Ribble Valley Borough Council  
Housing & Development Control

Your ref: 3/2024/0020  
Our ref: D3.2024.0020  
Date: 18<sup>th</sup> July 2024

App. no: **3/2024/0020**

Address: **Alston Dairy Alston Lane Longridge PR3 3BL**

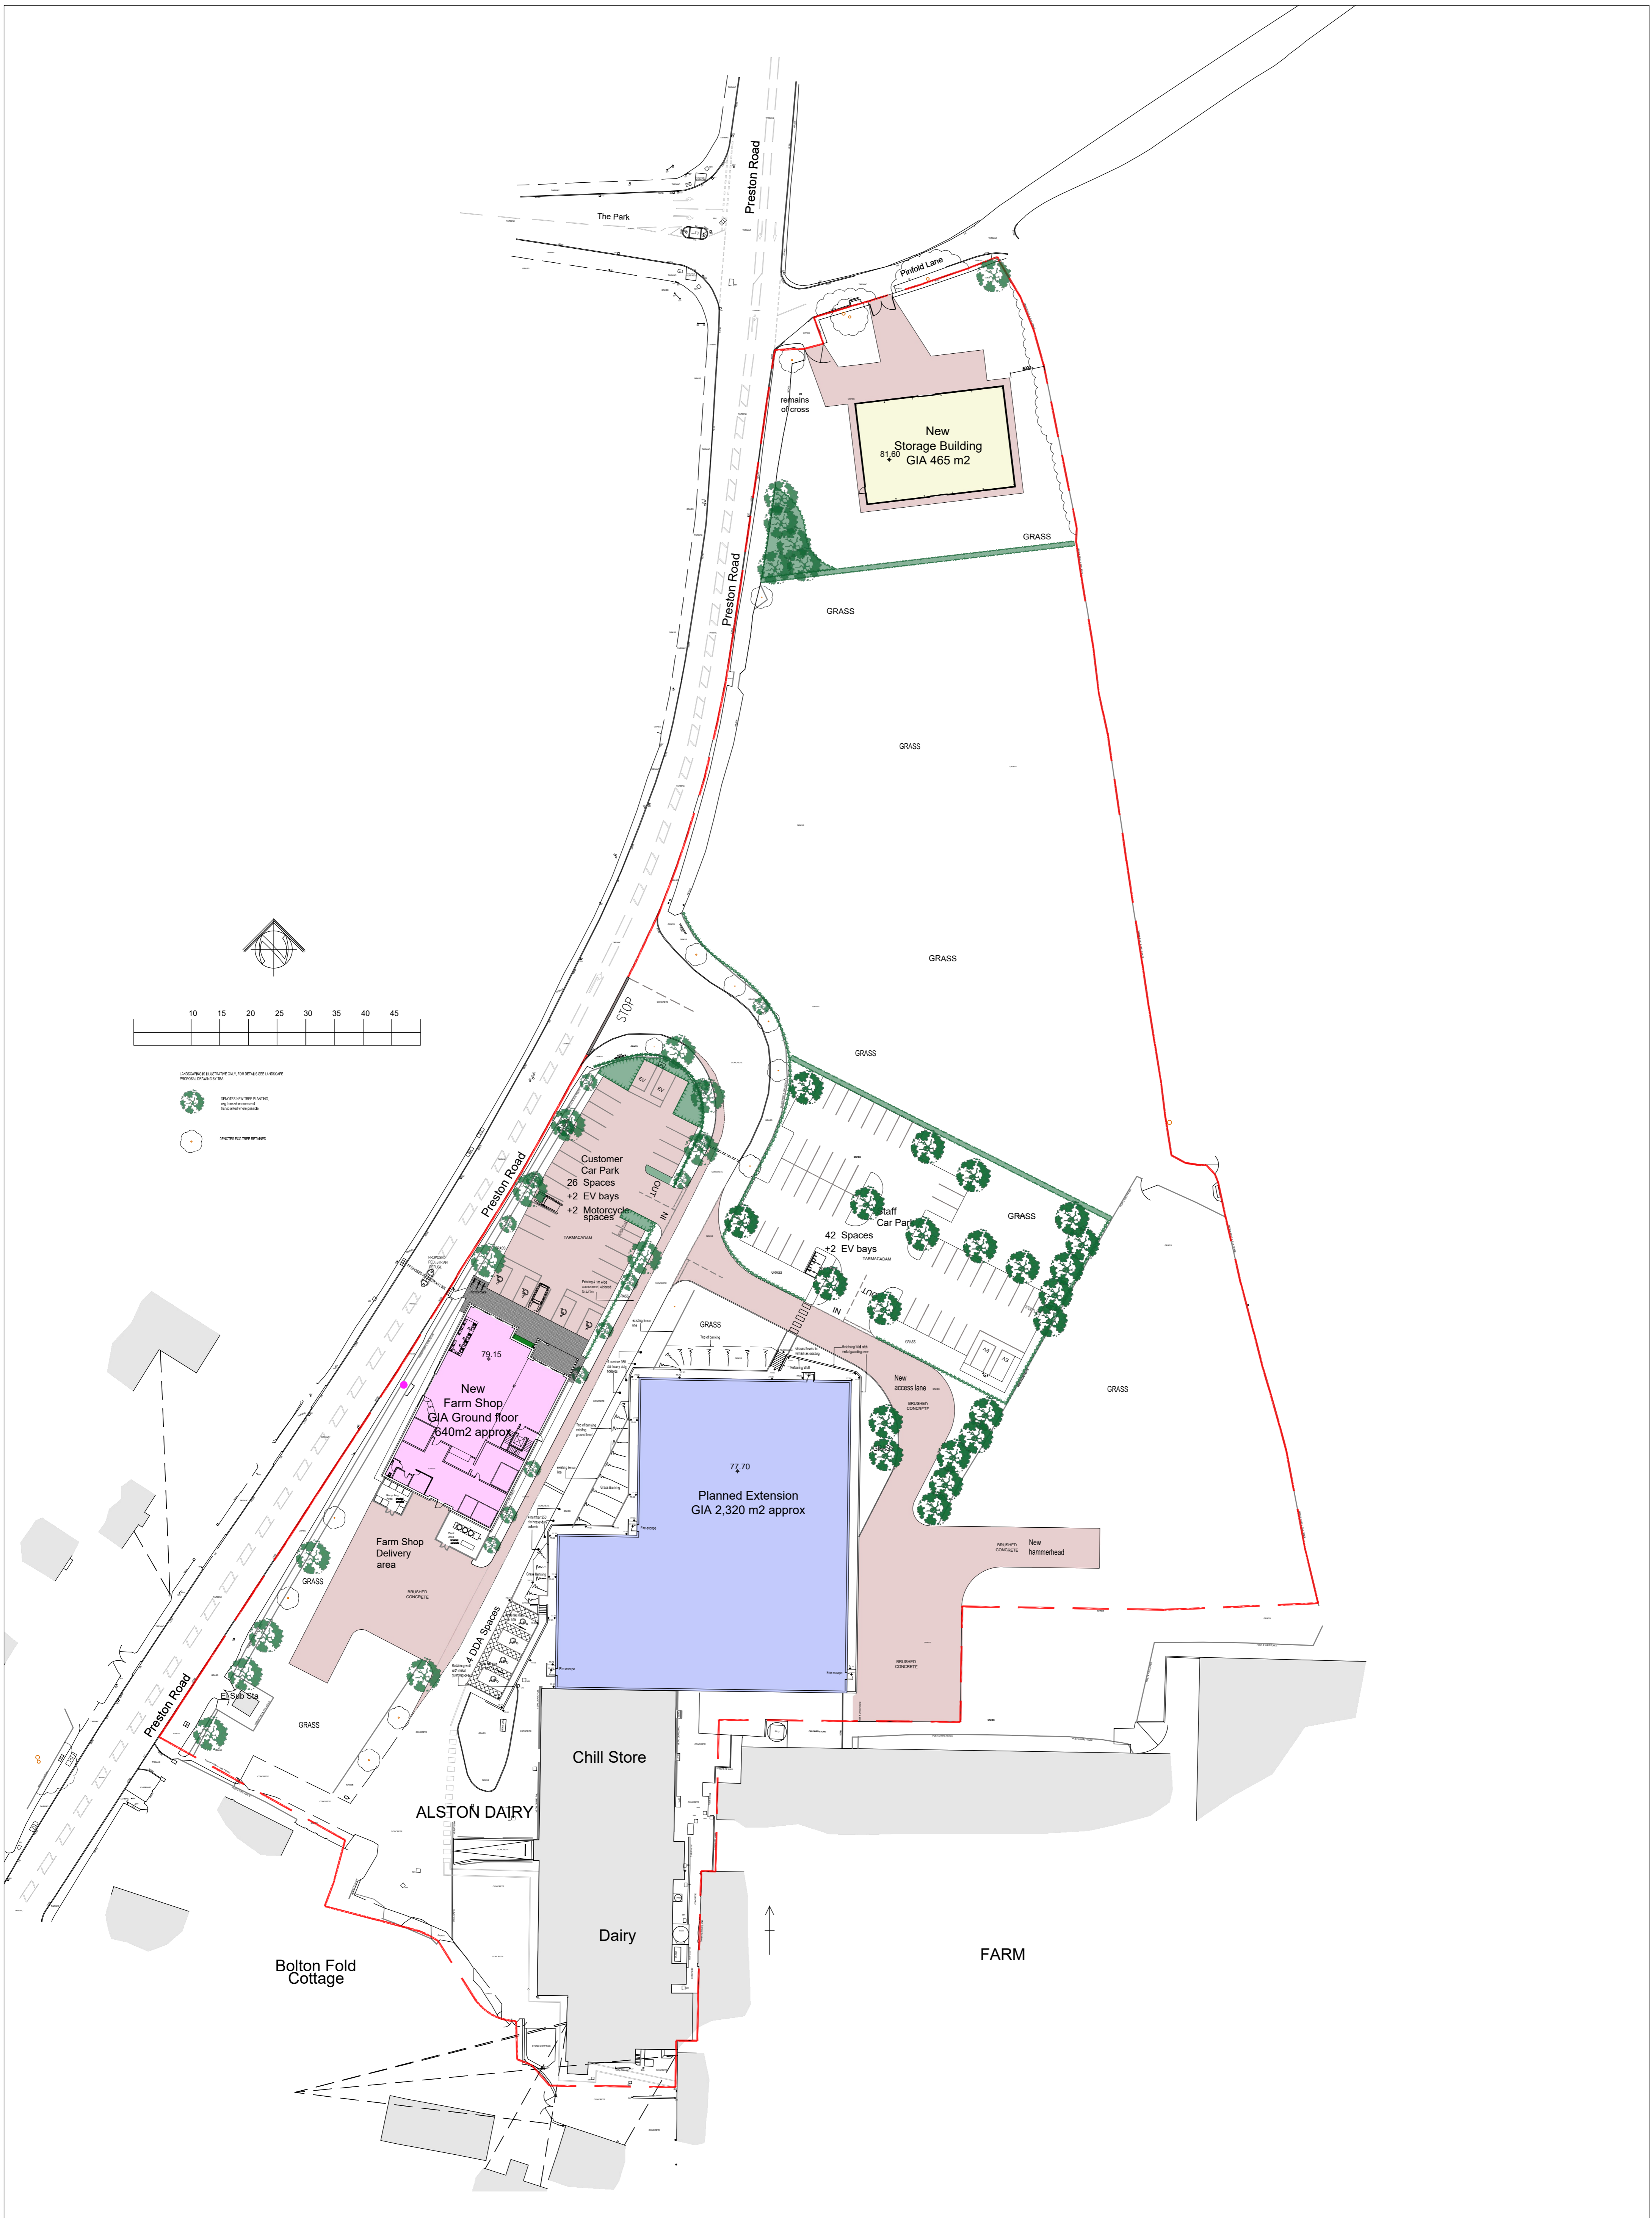
The proposed site access improvements on Preston Road shown on the drawing HWL drawing number PL-05 Rev R6 are agreed and we may request technical detail changes during the S278 agreement process.

We would request a planning condition to prohibit the use of the existing field gate to access the storage building.

As shown on the amended site plan R6, the storage building will be accessed through the main access on Preston Road.

1. Within 3 months of commencement a scheme for the site access and off-site highway works shall be submitted to and approved by the Local Planning Authority. The works shall include the following and be implemented prior to the first trading of the development hereby permitted.

- a. Improvement works on Preston Road to include widening of right turn lane with new central refuges, new footway to the east side of Preston Road and footway clearance of vegetation on the west side.
